Afra Construction, on behalf of West Mesa RV Park formerly known as Paradise RV Park, request Final Sign Off for Site Development Plan approved by EPC

REFERENCE: WEST MESA PARK – FORMERLY KNOW AS PARADISE RV PARK

PROJECT NO: 1008330 / EPC -40073 PHASE II. AND PROJECT NUMBER PR-2024-010907- DFT APPLICATION NUMBER SI-2024-01331.

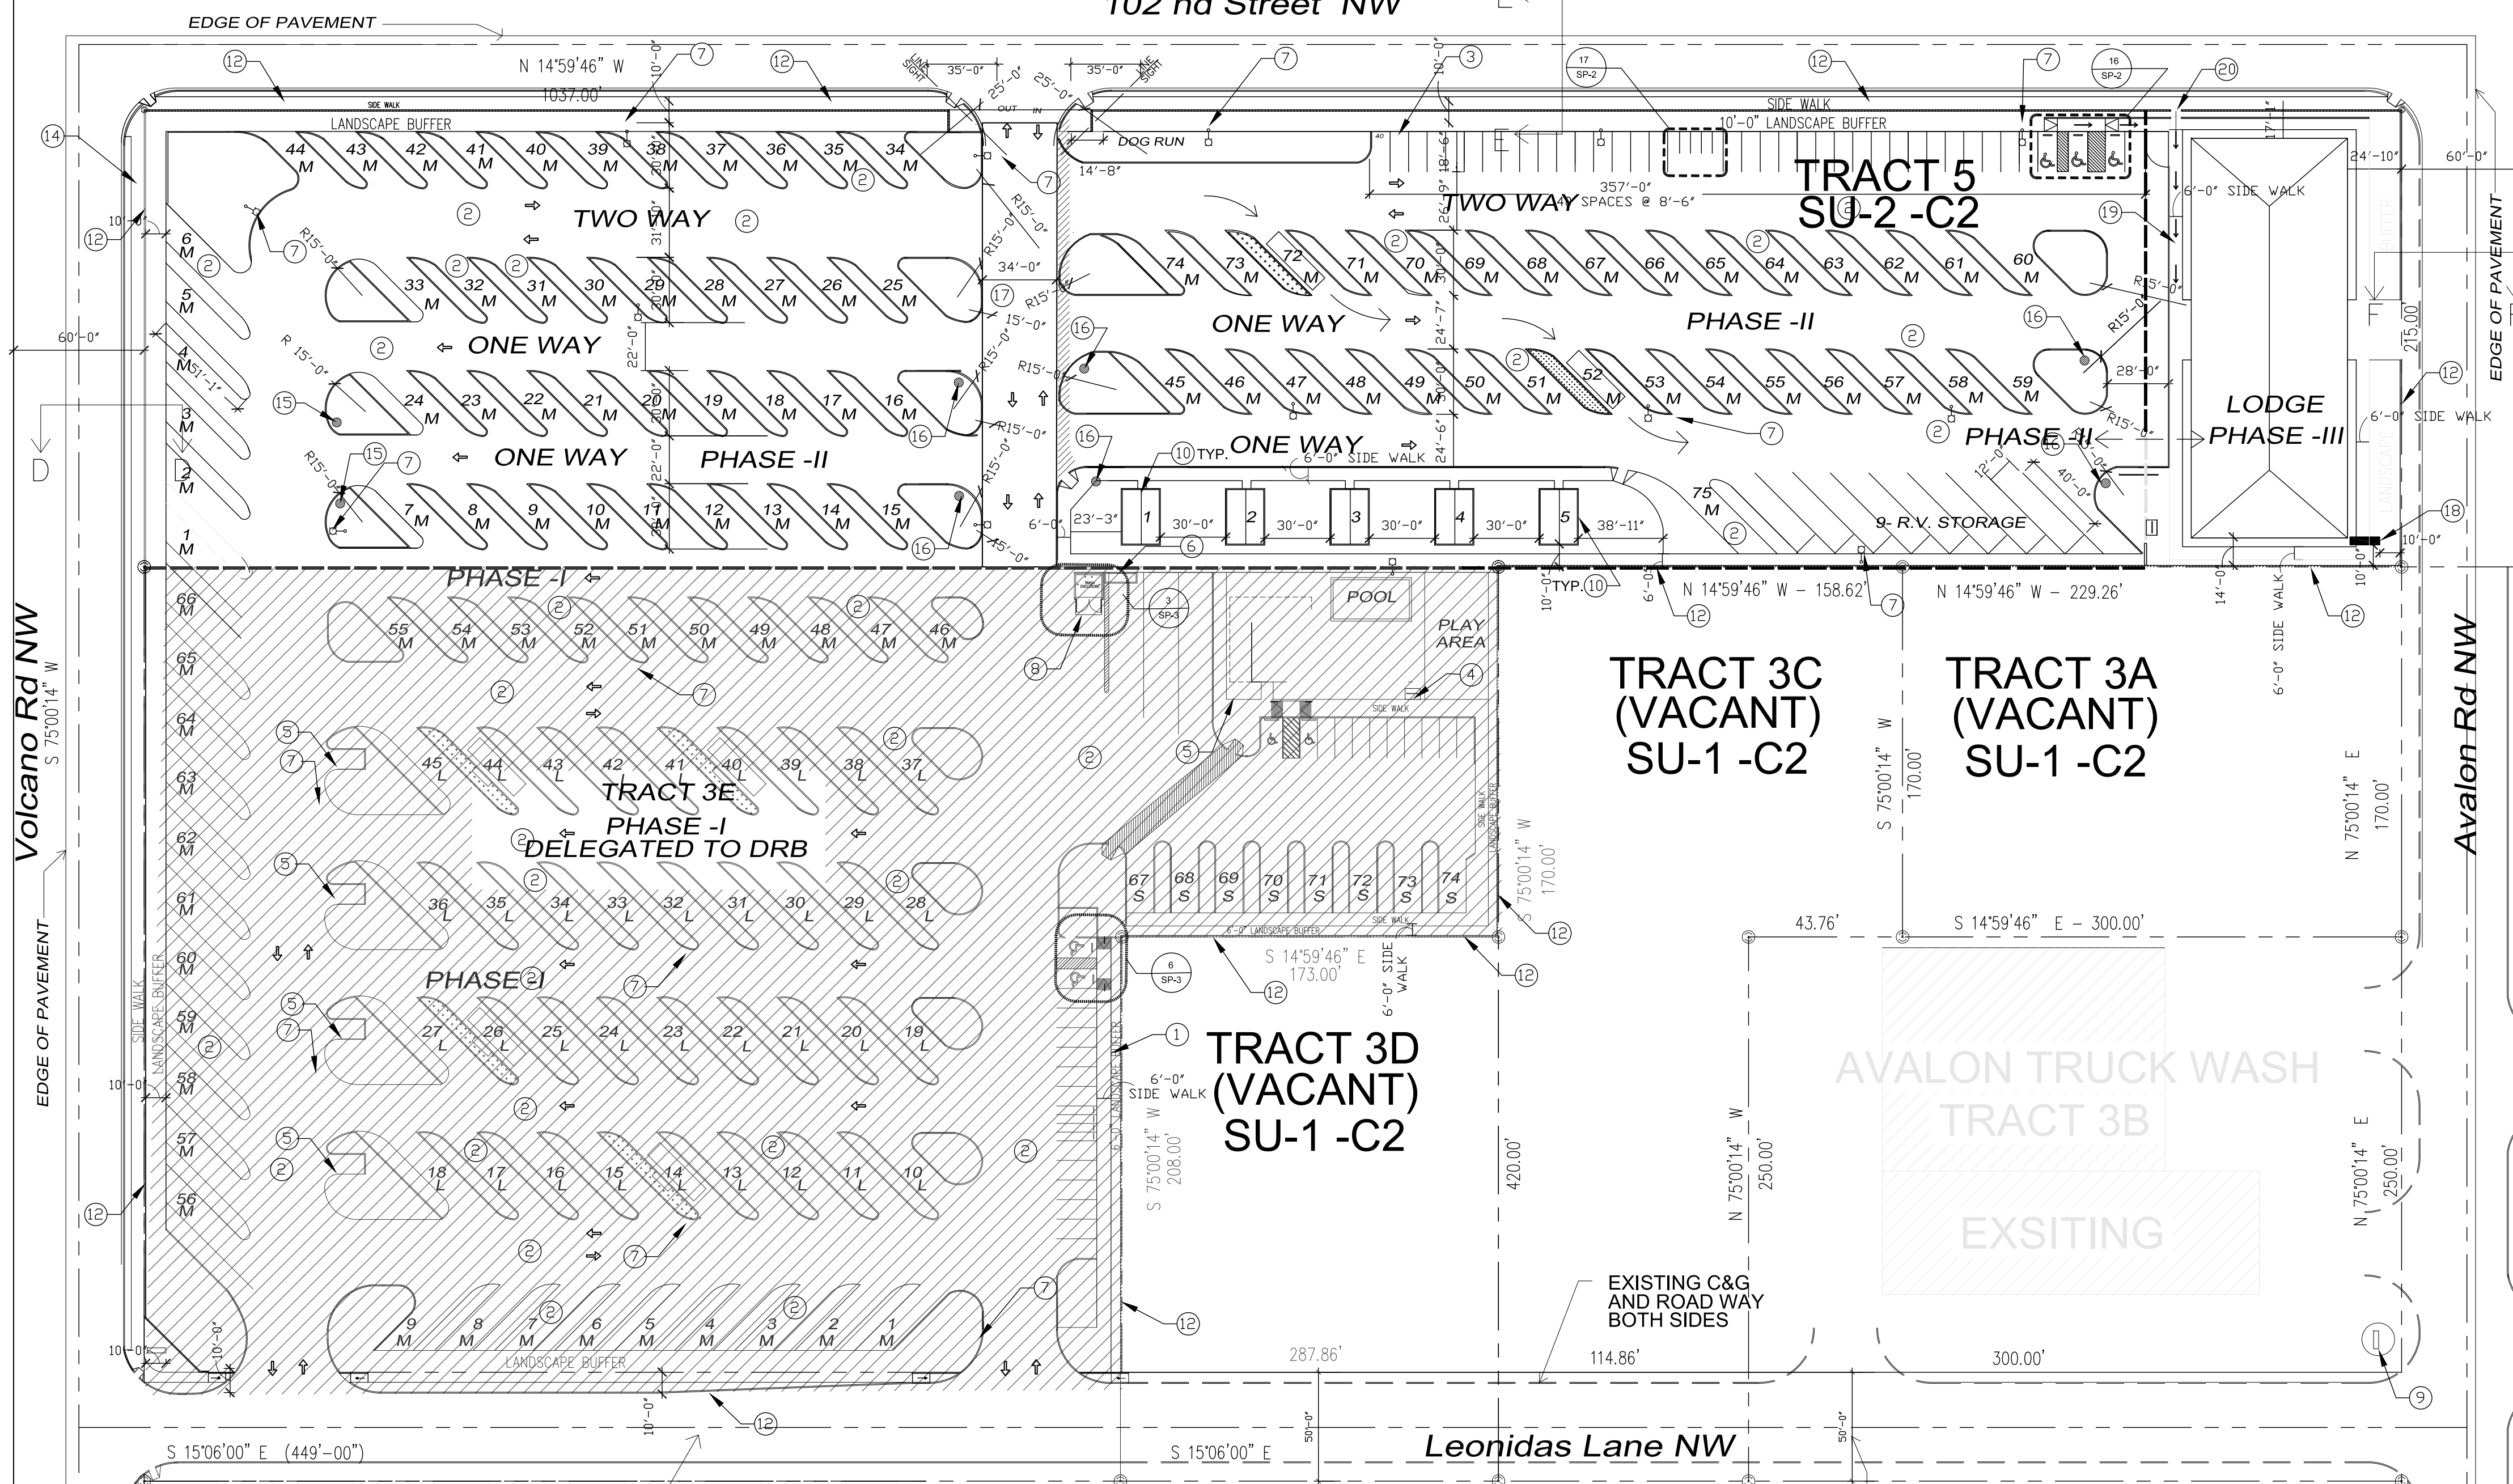
- i. All easements need to be shown and labeled on Site Plan.

**Sheets SP-1 and SP-2 show the easements.**

1 RV CENTERLINE TURNING RADIUS
SP-2 N.T.S TEMPLATE

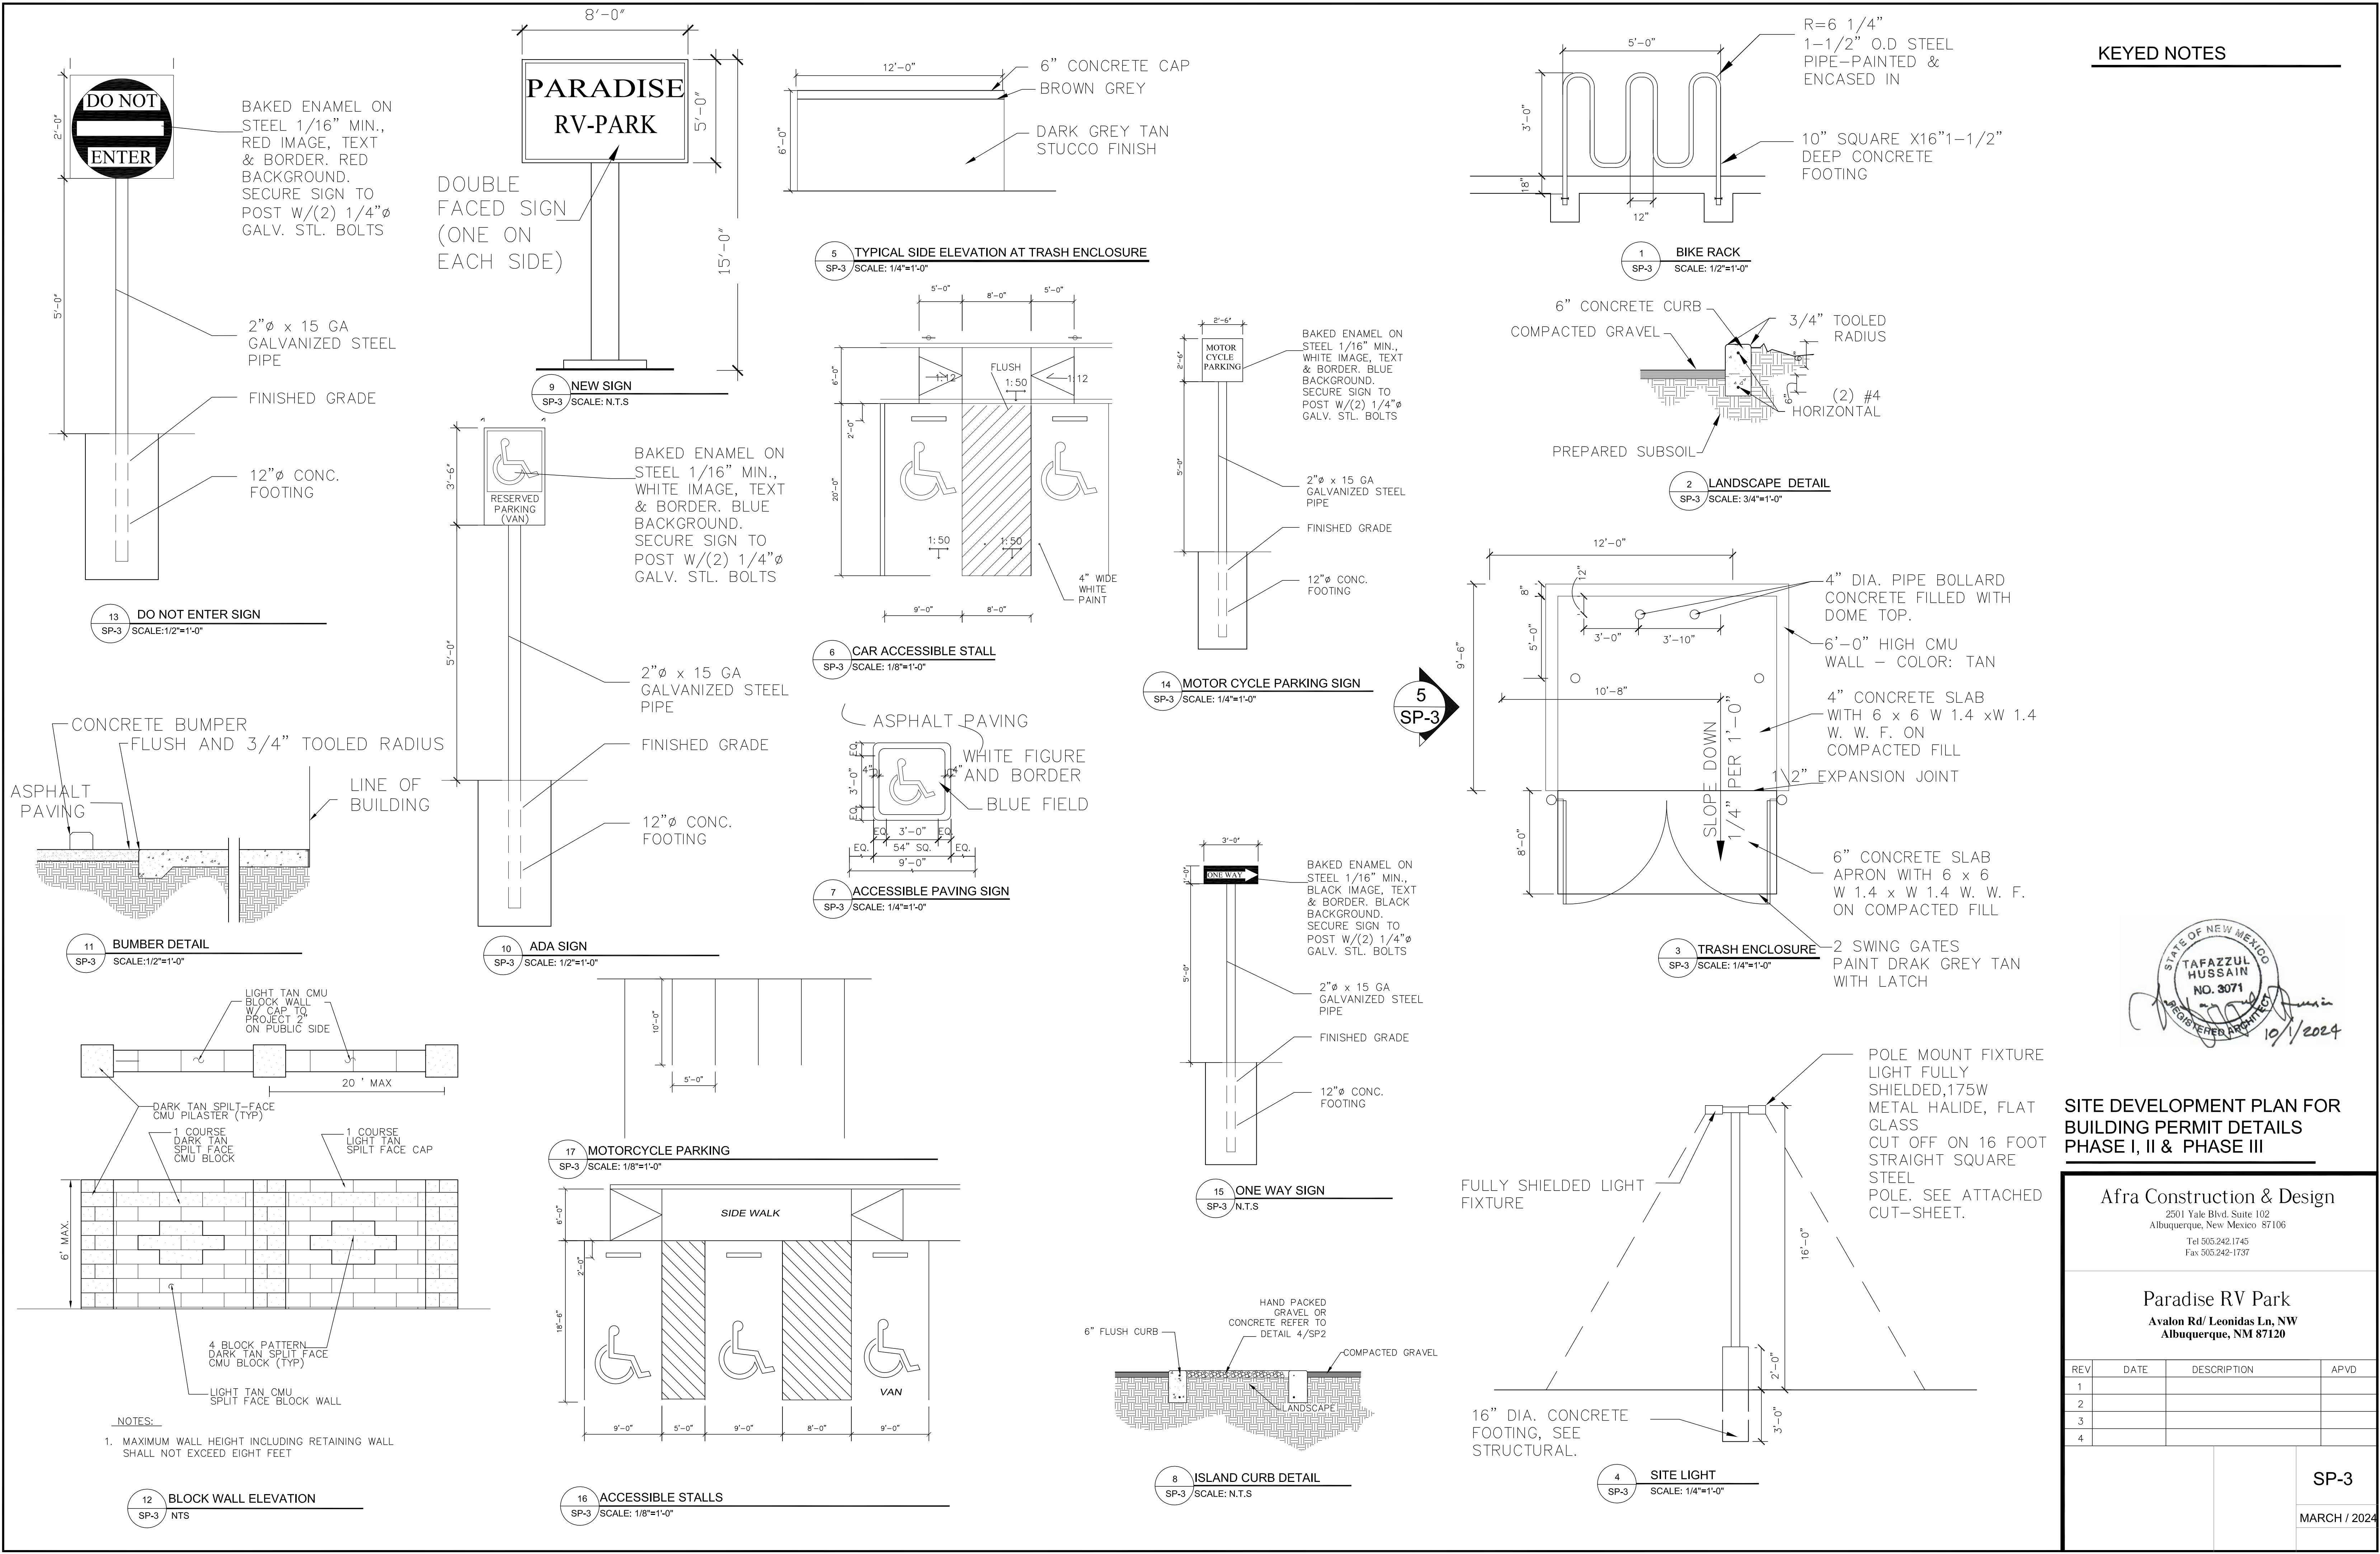
8. Conditions of approval for the proposed Site Development Plan for Building Permit from the City Engineer, Municipal Development and NMDOT include:
  - a. A 34-foot wide roadway access easement is shown on the site plan; this easement must be a private access easement. Provide the recording information for the easement.

- b. Show/provide turning templates and routes for proposed RV's.

- g. Leonidas Lane is shown as a public right of way on the site plan; however, as-built information indicates that this is a private access easement. Please revise the notation and provide the recording information.

- h. Signage and pavement markings will need to be provided for one-way traffic.

**The Recording Information is shown on Sheet SP-2. Note No 17.**

**The RV Centerline Turning Radius Template and Routes of the**

**proposed RV's are Shown on SP-1 and SP-2**

**Recording Information: Document No: 1998126535 shown on Sheet SP-2**

**Sheet SP-2 shows the Pavement Marking and Note No.15 of Sheet SP-03 shows the "ONE WAY" sign.**
